**KIRKLEES METROPOLITAN COUNCIL
INVESTMENT & REGENERATION SERVICE**

DELEGATED DECISION TO DETERMINE PLANNING APPLICATIONS

Reference No:	2024/62/90428/E
Site Address:	27, Royd Avenue, Heckmondwike, WF16 9AJ
Description:	Erection of dormer windows to front and rear
Recommending Officer:	Elenya Jackson

DECISION - REFUSED

27 Royd Avenue, Heckondwike, WF16 9AJ
PROPOSED FLOOR PLANS & ELEVATIONS

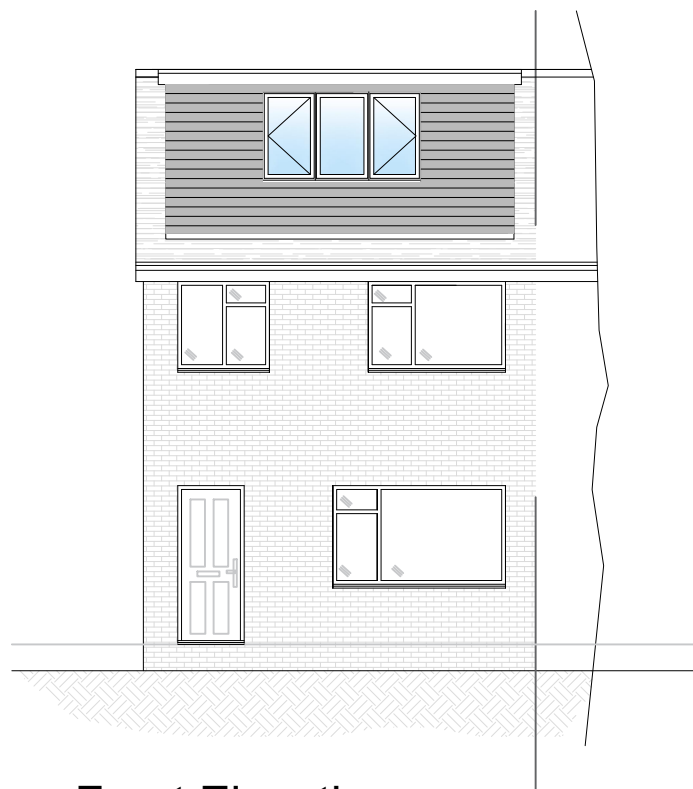
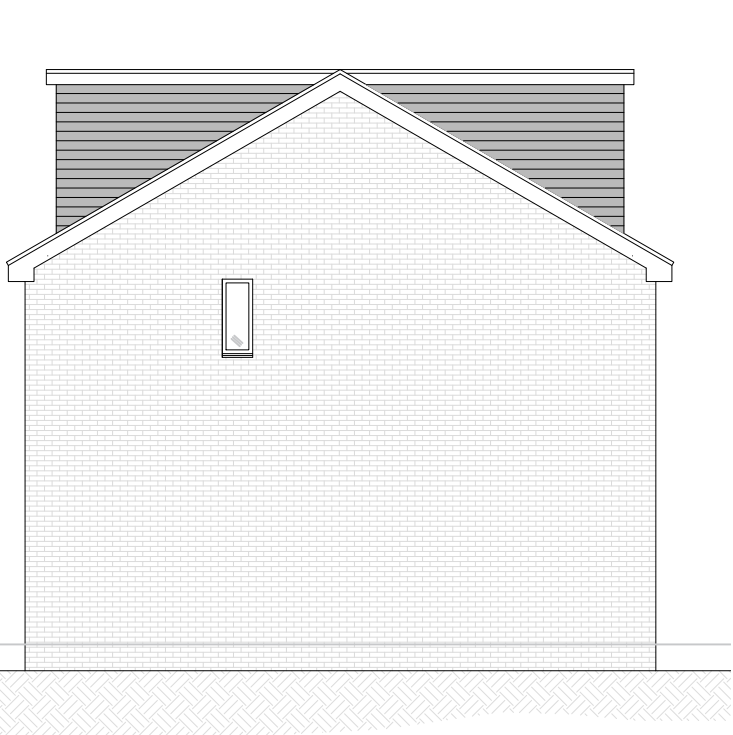
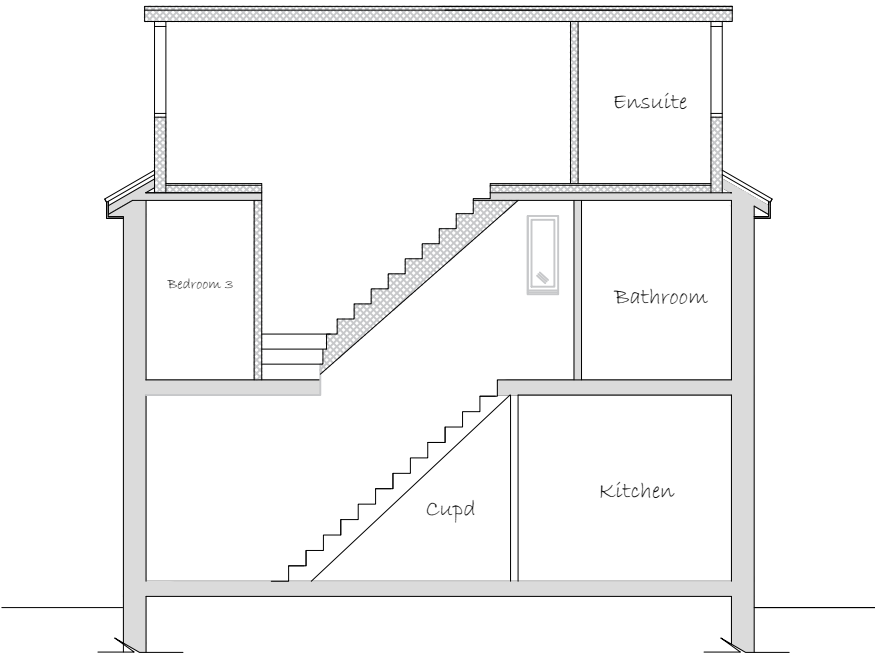
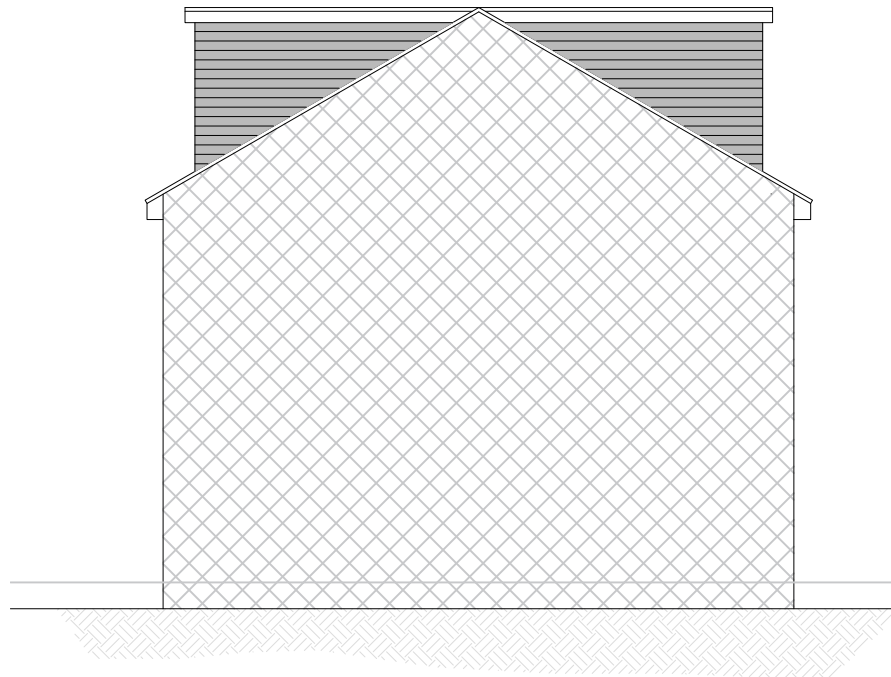
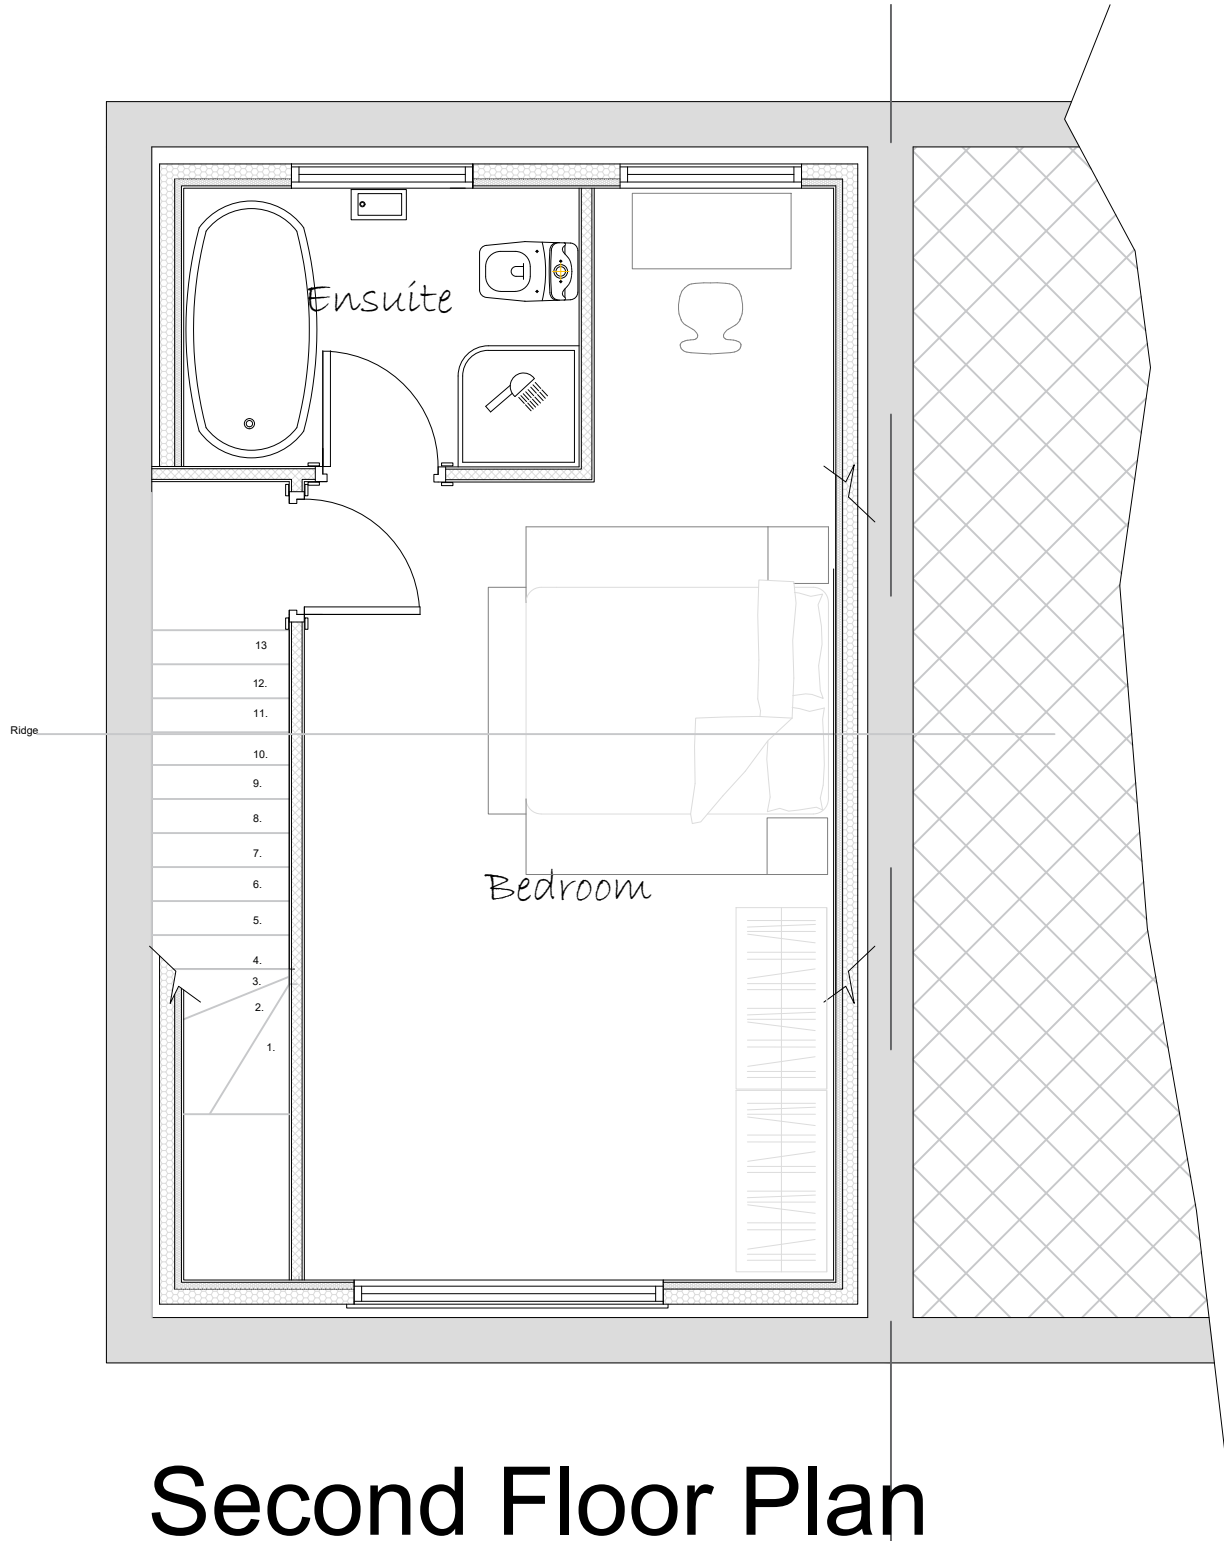
The proposal would be a box dormer to the front and rear elevation of the dwelling, those on the principal elevation would have a width of 4.6m, a height of 2.1m, 48cm above the eaves and project 3.8m. This would not be set down from the ridge of the host dwelling. The rear dormer would match

The proposed dormers would feature a flat roof, would not be set down from the ridge of the existing dwelling, would be large in scale and not be reflective of the prevailing character of the area. There are no existing dormers within the street scene or immediate building group and this would be the first such extension. The design and scale of the proposed dormers would not meet the policy set out in the SPD.

The rear dormer should be set down from the ridge but is generally of a comparative scale to that which would be permitted development. However, having taken into account the scale, mass and prominent location of the front dormer, the proposed extension would dominate the host and cause harm to the visual amenity of the wider street scene, failing to comply with Policy contained in the SPD as well as Policy LP24 of the Kirklees Local Plan (a) in terms of the form, scale and layout and (c) as the extension would not form a subservient addition to the property or be keeping with the existing building.

1. Due to the design, scale, form and prominent location, the proposed front dormer would appear discordant, overly prominent and domineering to the host dwelling and obtrusive within the street scene. The proposal would fail to respect the character of the host dwelling and would be read as a discordant and incongruous feature within the street scene and wider area. The proposal fails to meet Kirklees Local Plan Policy LP24 in terms of the character of the host property and the criteria of the Kirklees House Extension Supplementary Planning Document paragraph 5.27 and KDP 1 & 2 in terms of the character of the area and the impact on the original house.
